APPLICATION FOR A NON MATERIAL AMENDMENT UNDER SECTION 96A OF THE TOWN AND COUNTRY PLANNING ACT (1990) ACT TO REF. 75111/APP/2022/1007 IN CONNECTION TO CONDITIONS 2 AND 10 WITH REGARDS TO:

- **ENERGY CENTRE 2**
- **ENERGY CENTRE 3**
- **CANAL ACCESS RAMP**

LAND AT BULLS BRIDGE INDUSTRIAL ESTATE, NORTH HYDE GARDENS, HAYES, UB3 4QQ

7 03050 - Roof
1 : 200

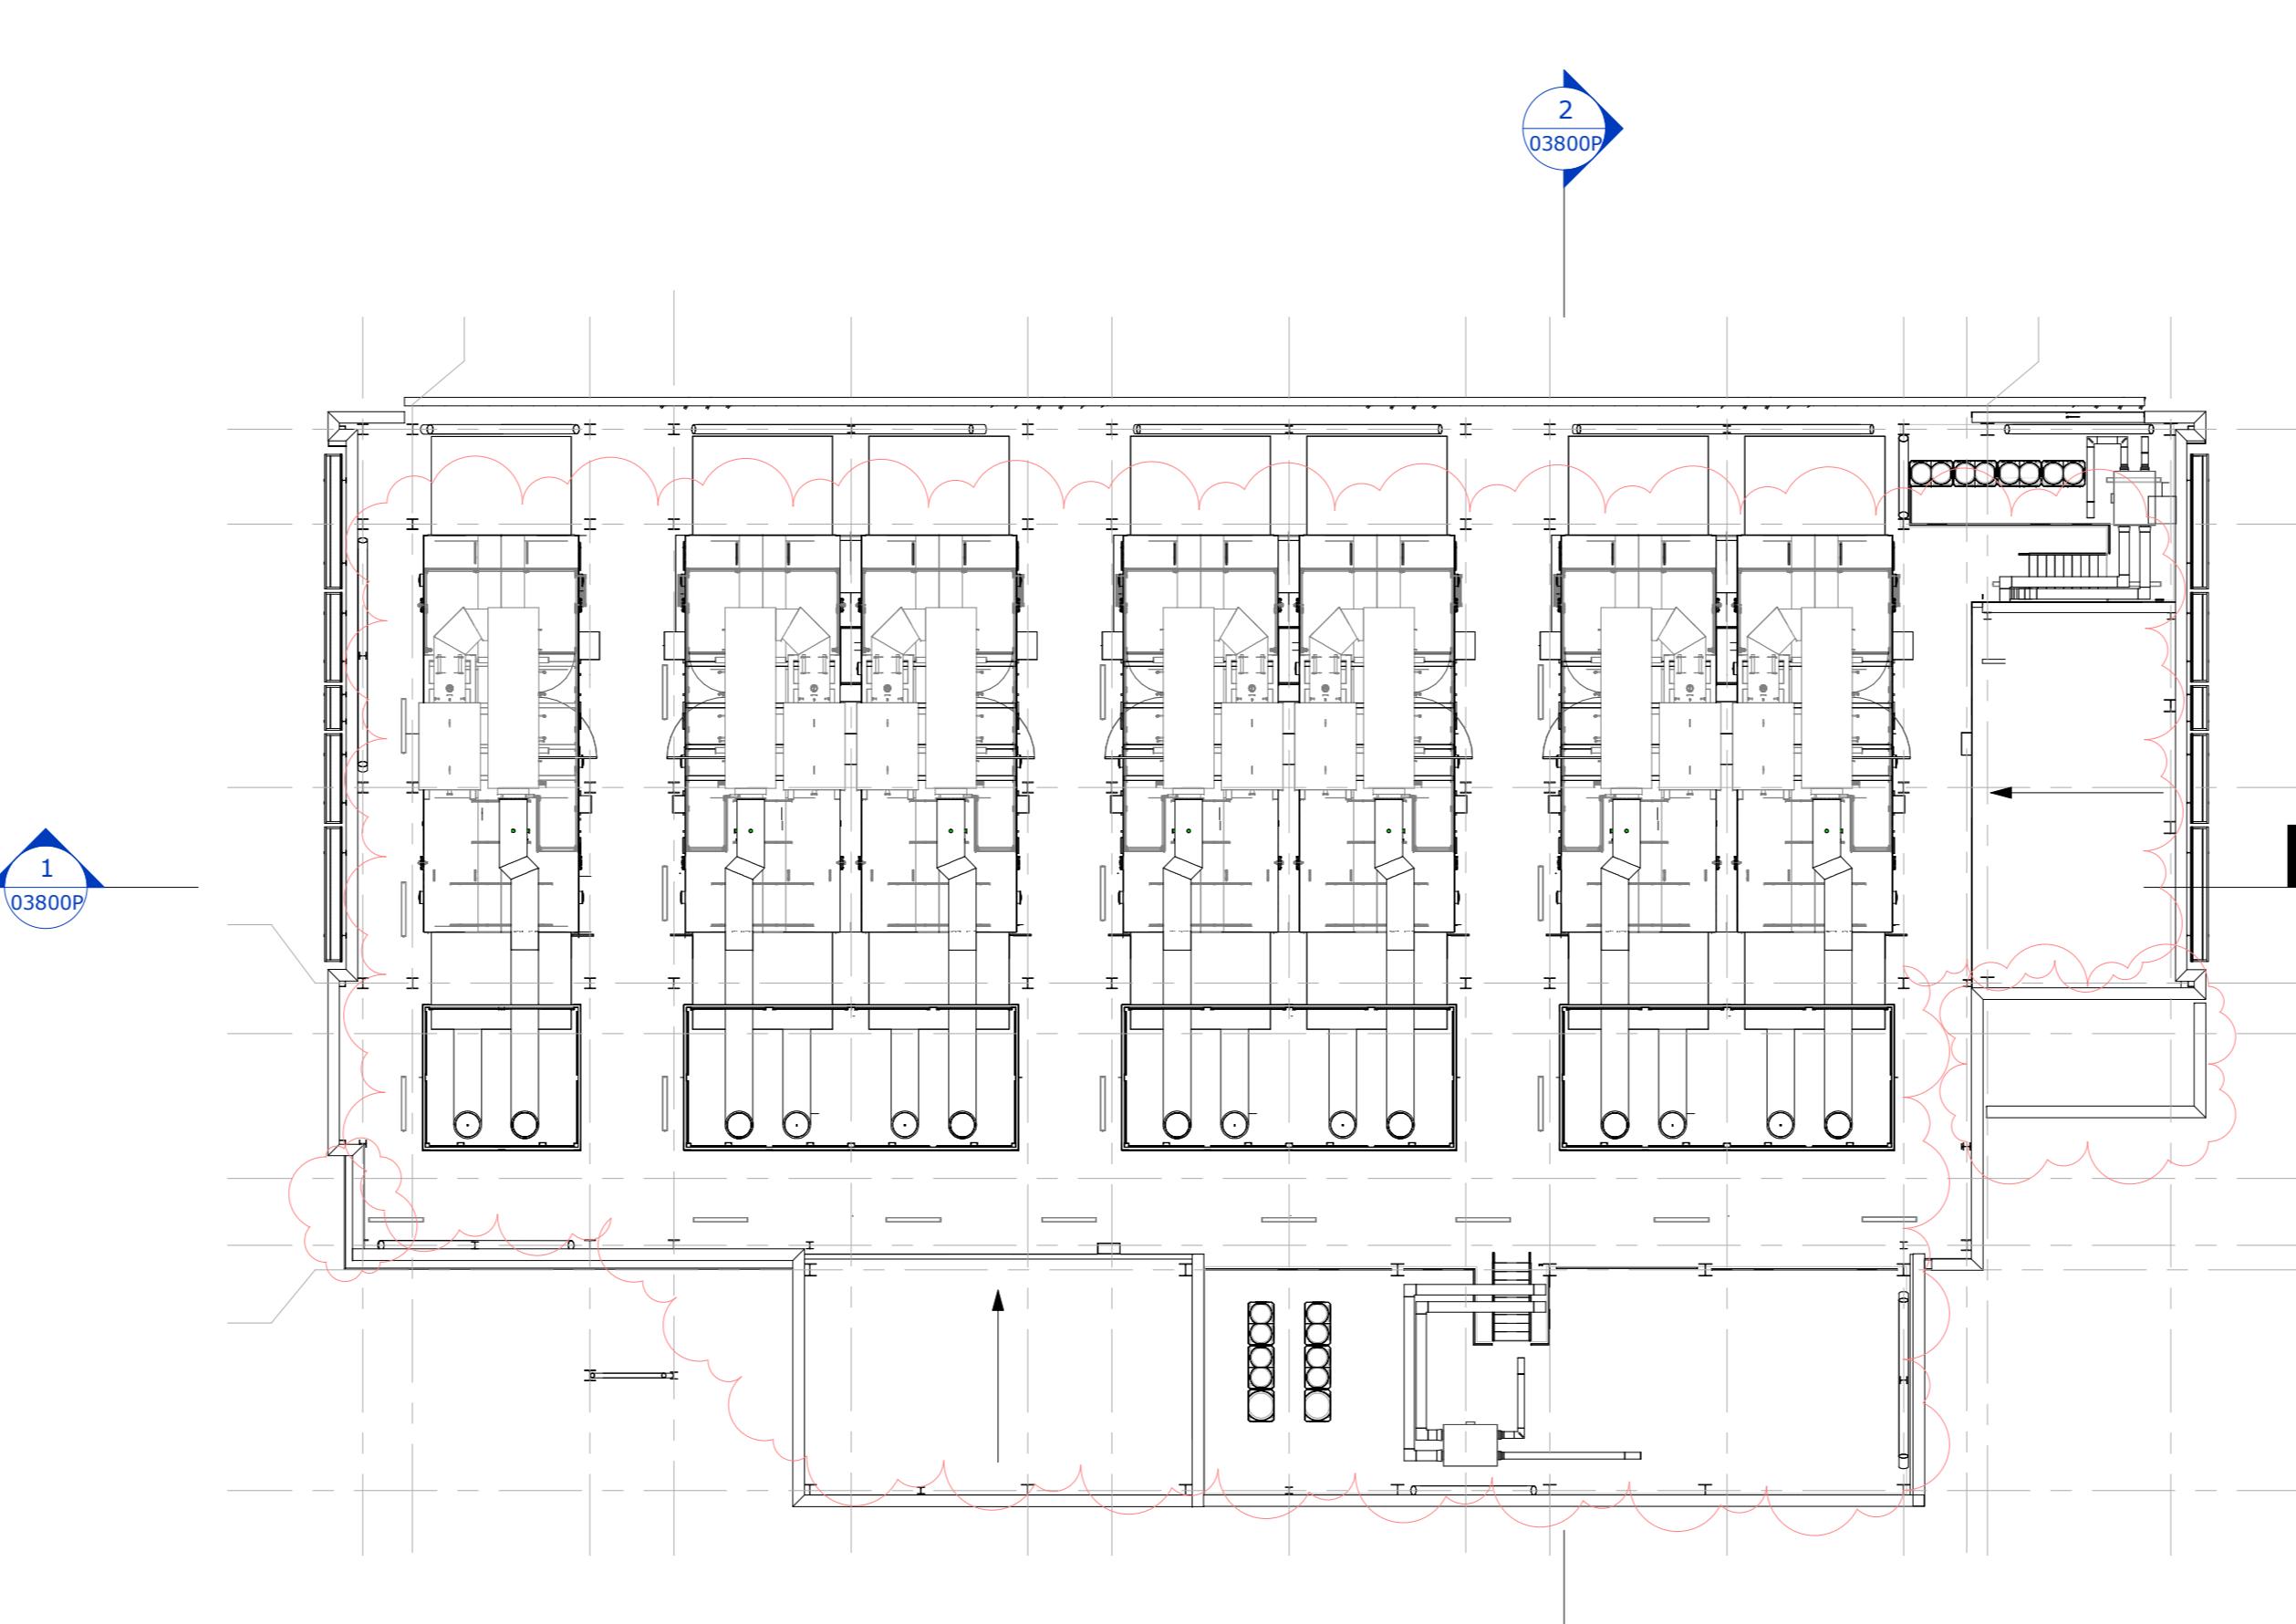
- Installation of an additional staircase at the southeastern corner of the building. This will be clad in the same materials as the wider building;
- Modest refinement of the footprint of Energy Centre 2 along its western and southern boundary. As shown on the plans submitted, these changes are modest in the extreme and could reasonably be considered to be de minimis;

- To facilitate plant replacement, there is a requirement for the replacement of the brickwork along the northern elevation of Energy Centre 2 with louvres and the replacement of landscaping with planters to facilitate access;

- Reconfiguration of the green wall arrangement along the building's southern and western elevations. Importantly, the quantum of green walling (and the urban greening factor that is achieved) remains unchanged; and

- Reconfiguration of the building's internal arrangement which will mean that the heat rejection stacks will no longer be visible.
